File: 2014/1778

Tuesday, 21 April 2015

**RE: BCA Assessment – DA Submission R4.0
Taronga Zoo Sumatran Tiger Adventure**

2 VILLAGE SHOPFRONTS - ELEVATION
1:100

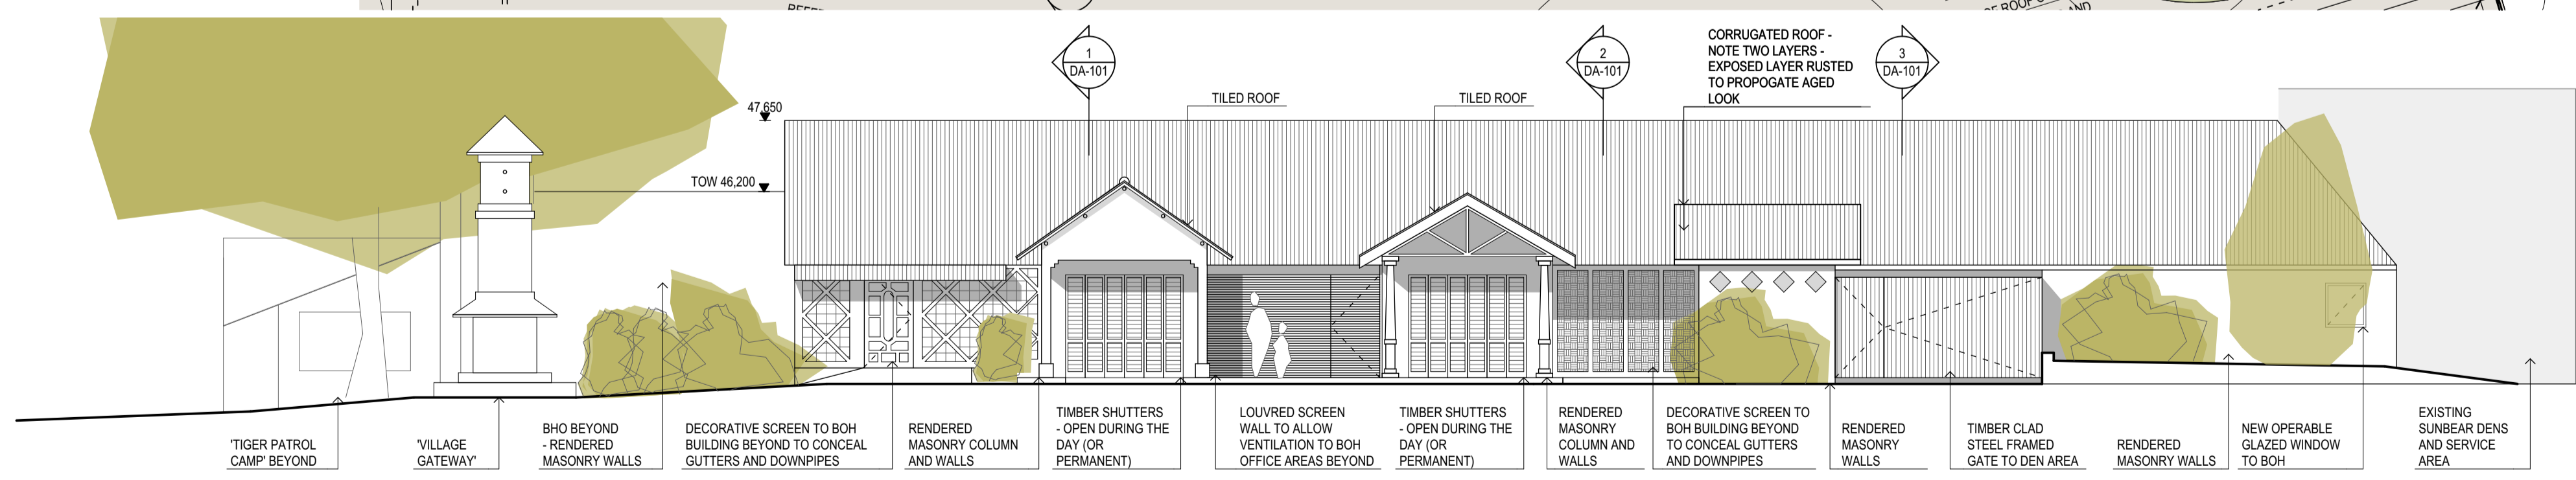
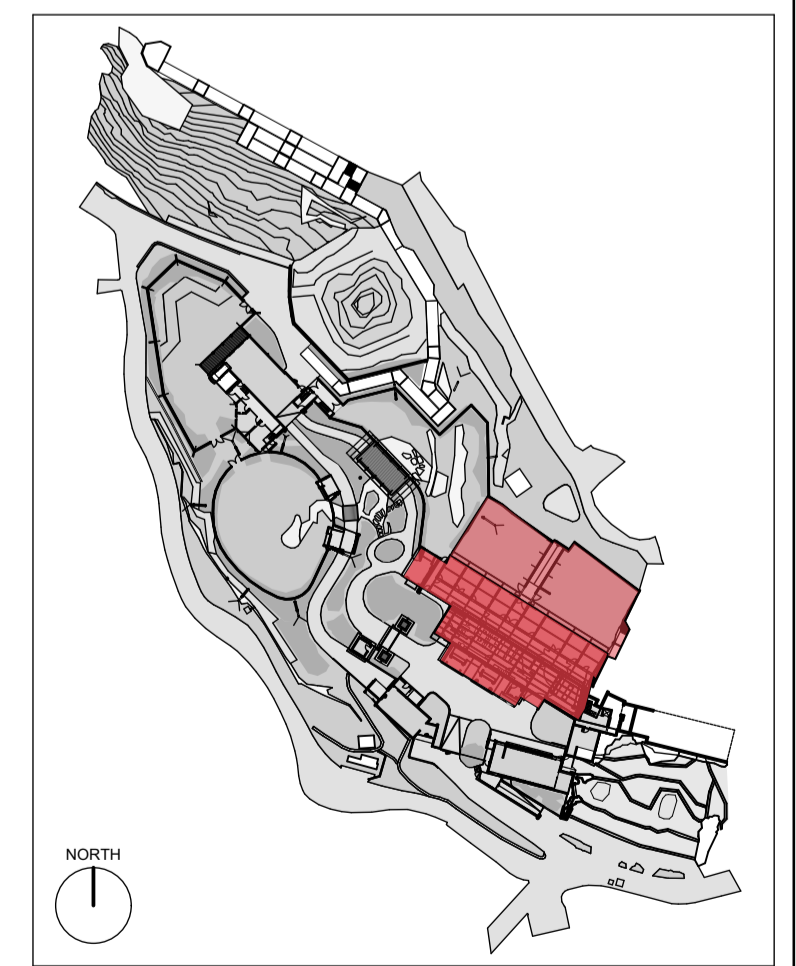
- The accessible WC is required to comply with the requirements of AS1428.1-2009.
- The doorway into the shop area is required to have door circulation spacing in accordance with AS1428.1-2009. A minimum of 1240mm clear is required in front of the doorway as shown below.

<p>Currently the clearance is 1030mm.</p>

**1 ENTRY BUILDING - FLOOR PLAN**  
1:100

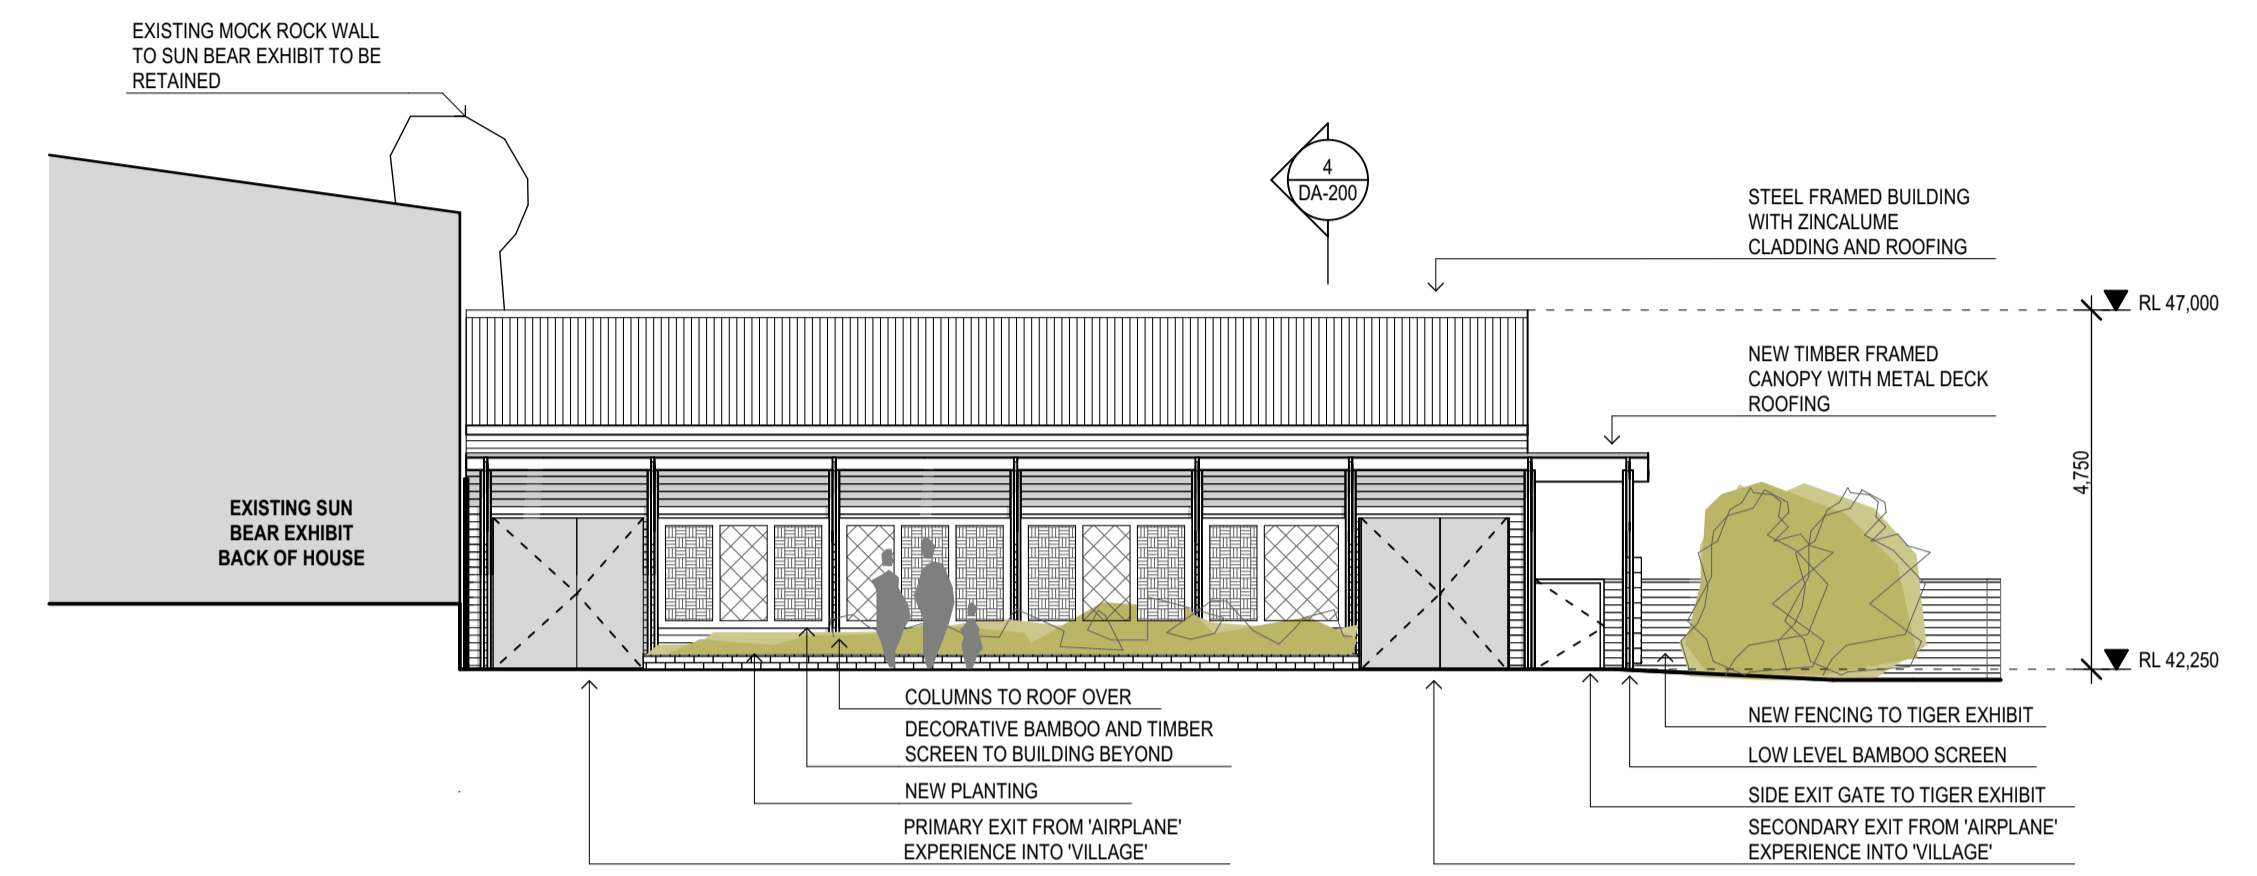
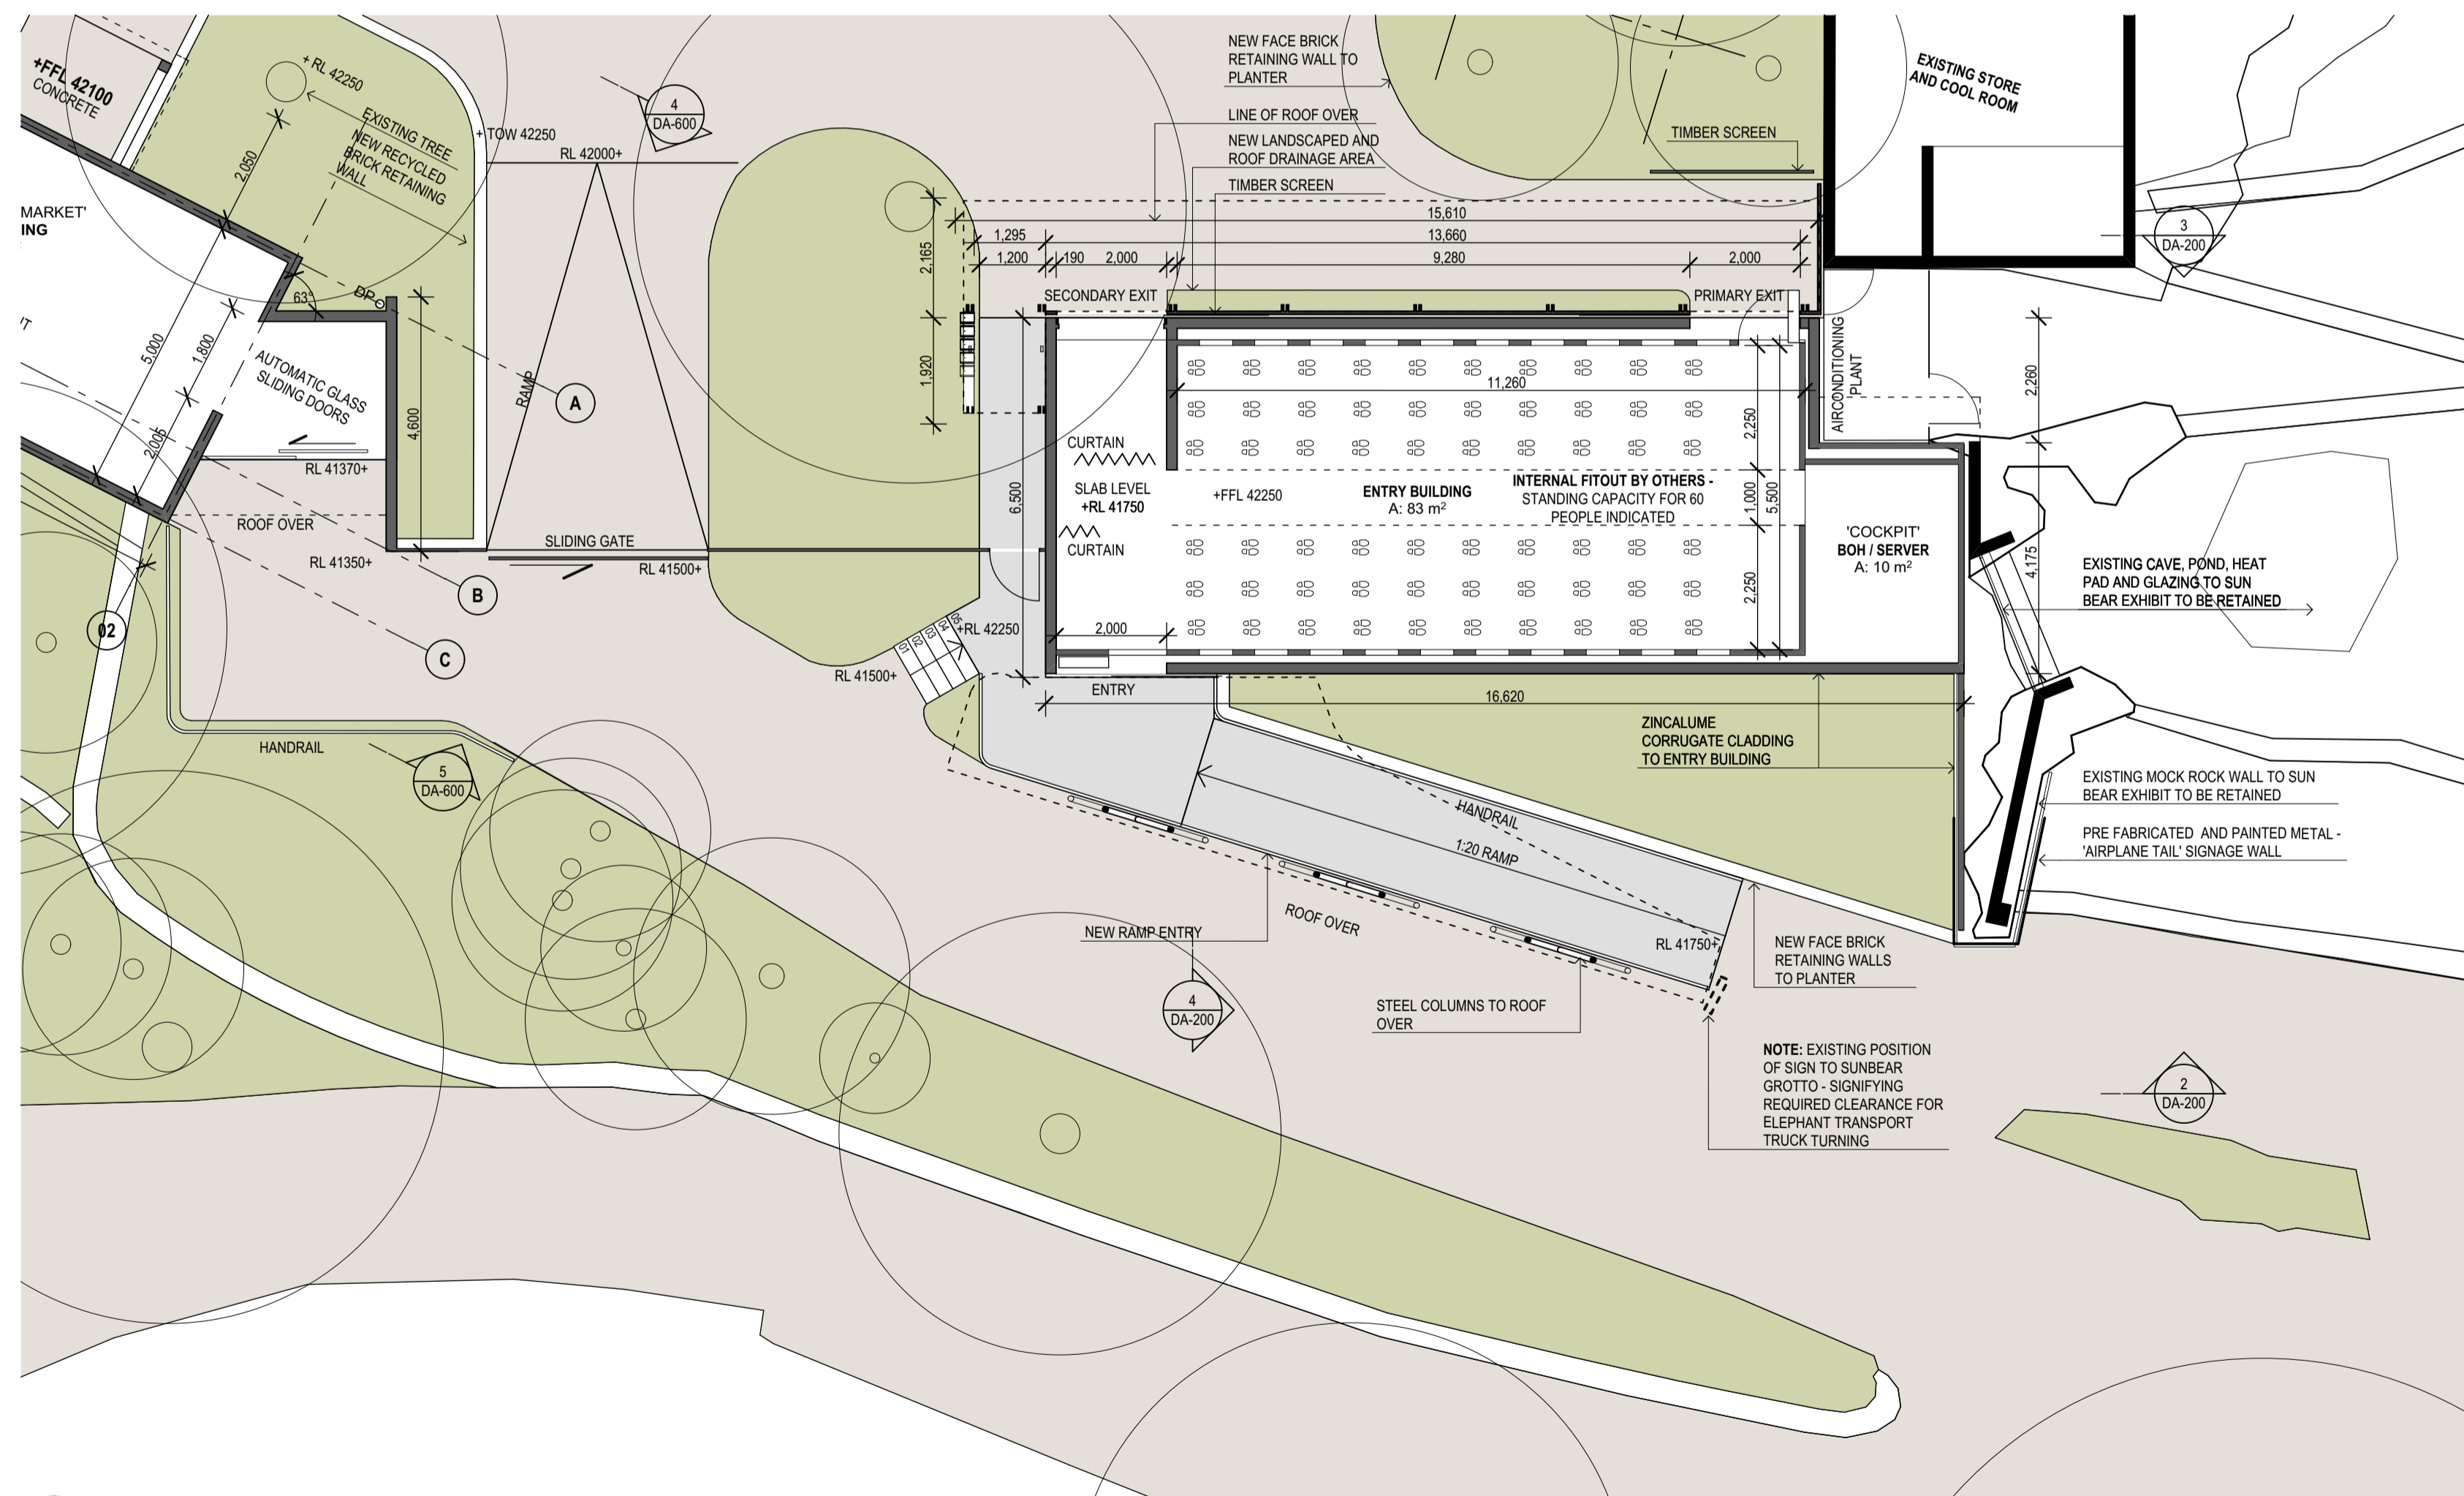
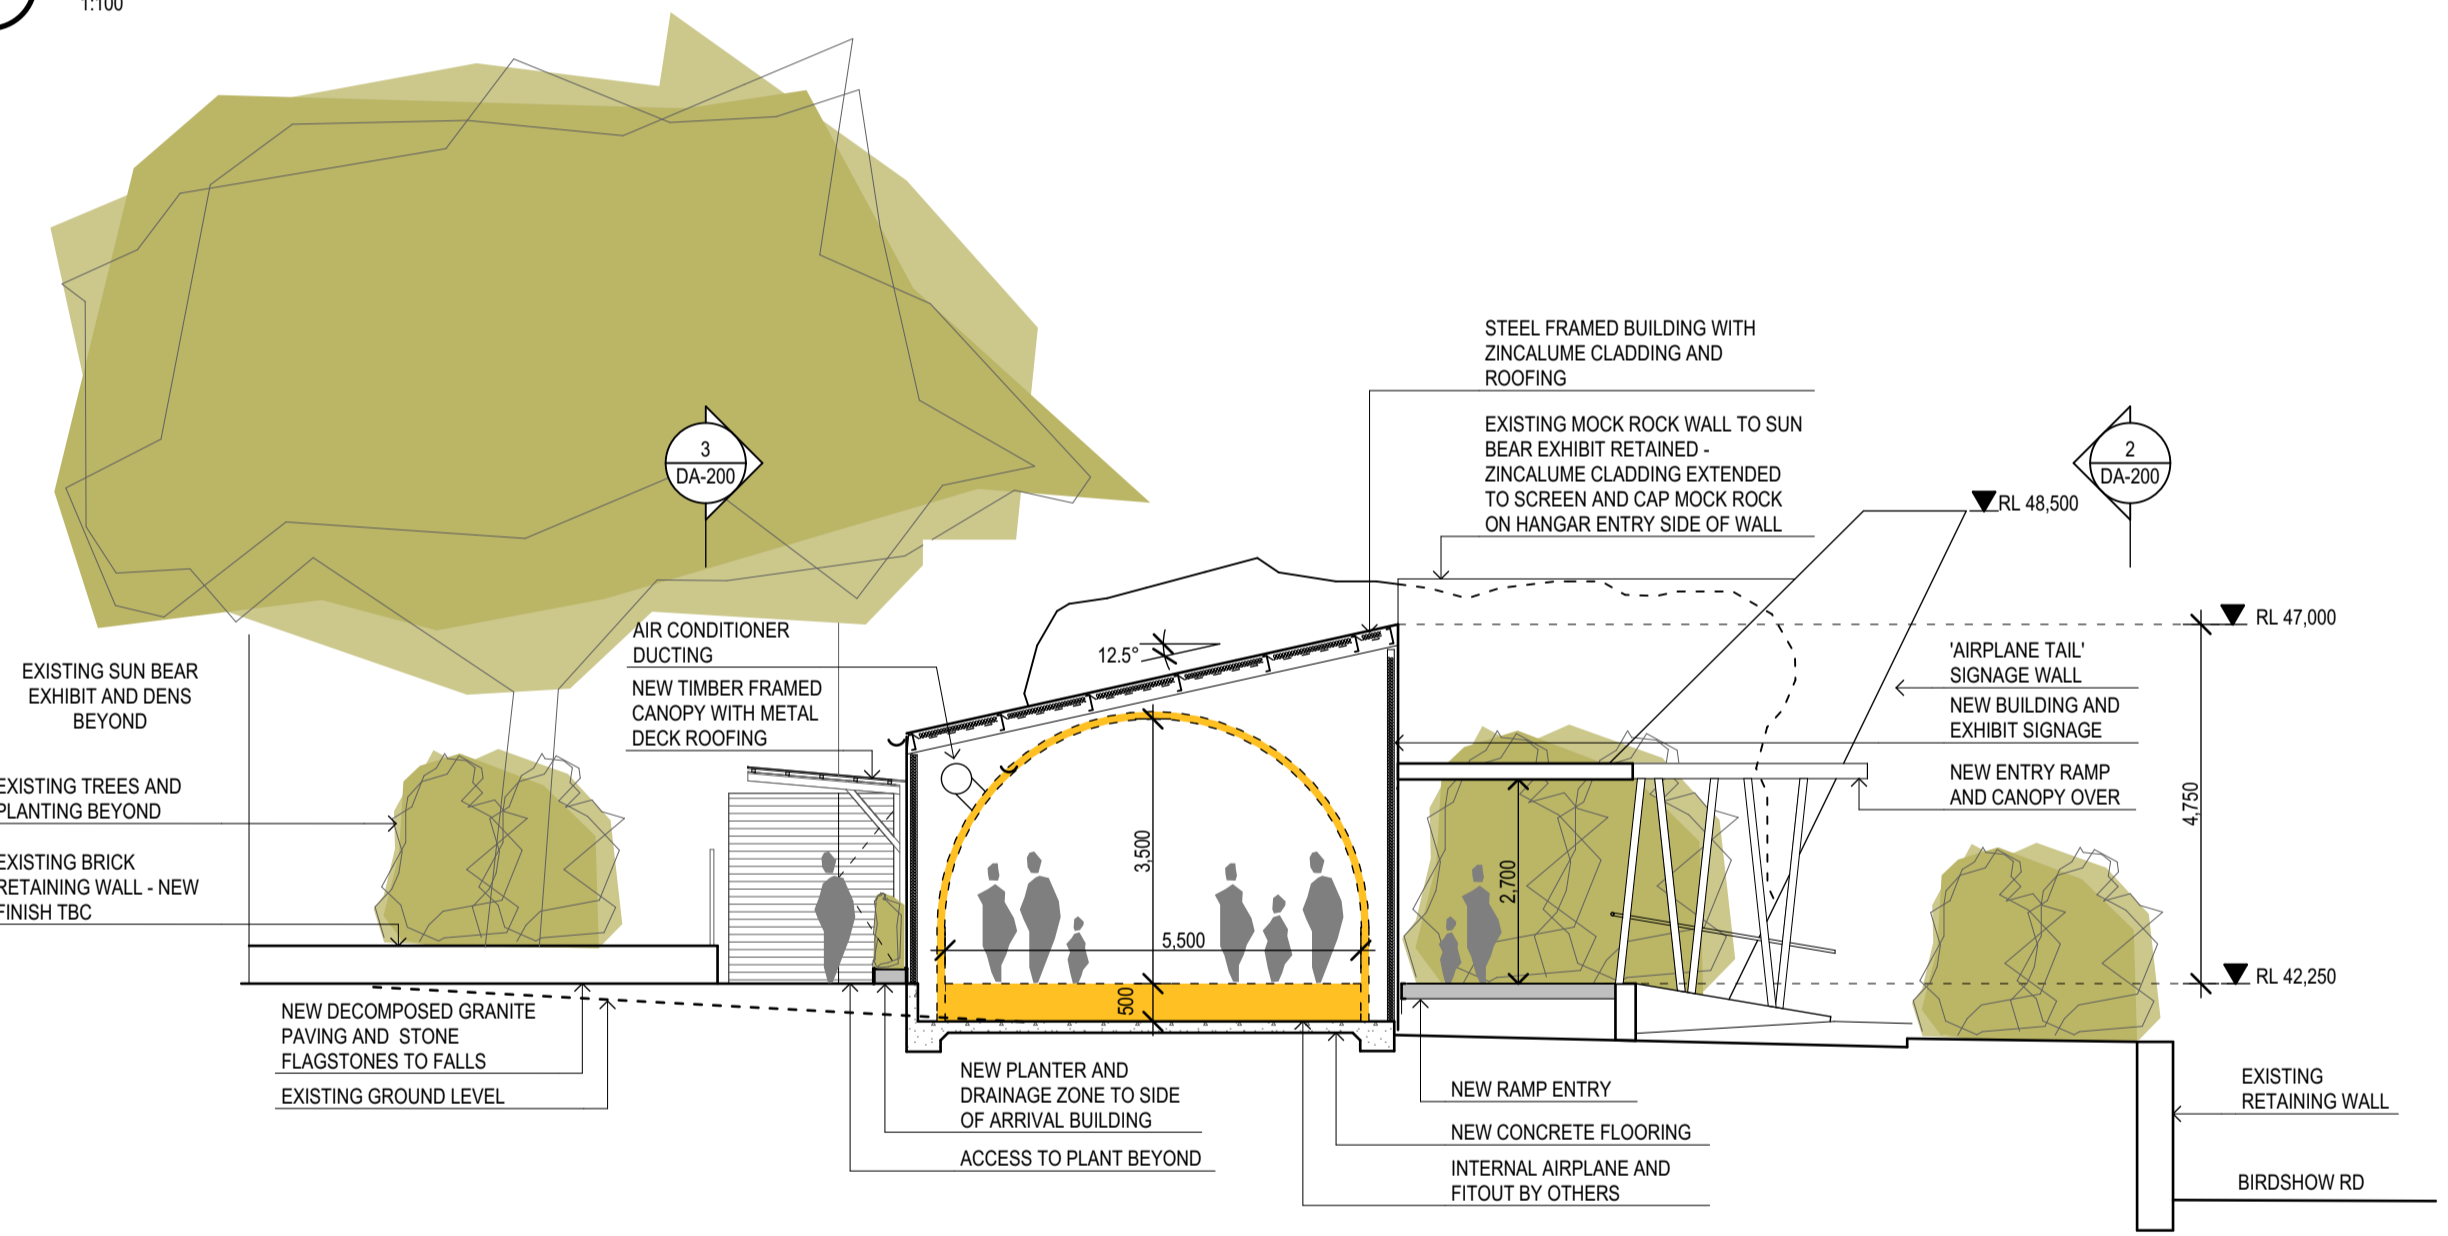
1.	The treads and risers to the stairway entry are to comply with the below requirements of Clause D2.13: <ul style="list-style-type: none"> • Riser – Max 190mm, Min 115mm • Going – Max 355mm, Min 250mm • Risers which do not have any openings that would allow a 125mm sphere to pass through between the treads

2.	The tread or landing surface of the entry stairway is to have a slip resistance rating of P4 or R11 in accordance with Table D2.14.
3.	The nosing or landing edge strip of the entry stairway is to have a slip resistance rating of P4 in accordance with Table D2.14.

4.	The threshold of the entry and exit doorway of the building must not incorporate a step in accordance with Clause D2.15.
5.	The stairway entry is required to have handrails to both sides and tactile indicators as shown in the below diagram from AS1428.1-2009:

6. The exit doorway is required to have door circulation spacing in accordance with Figure 31 of AS1428.1-2009. Required door circulation is shown below:
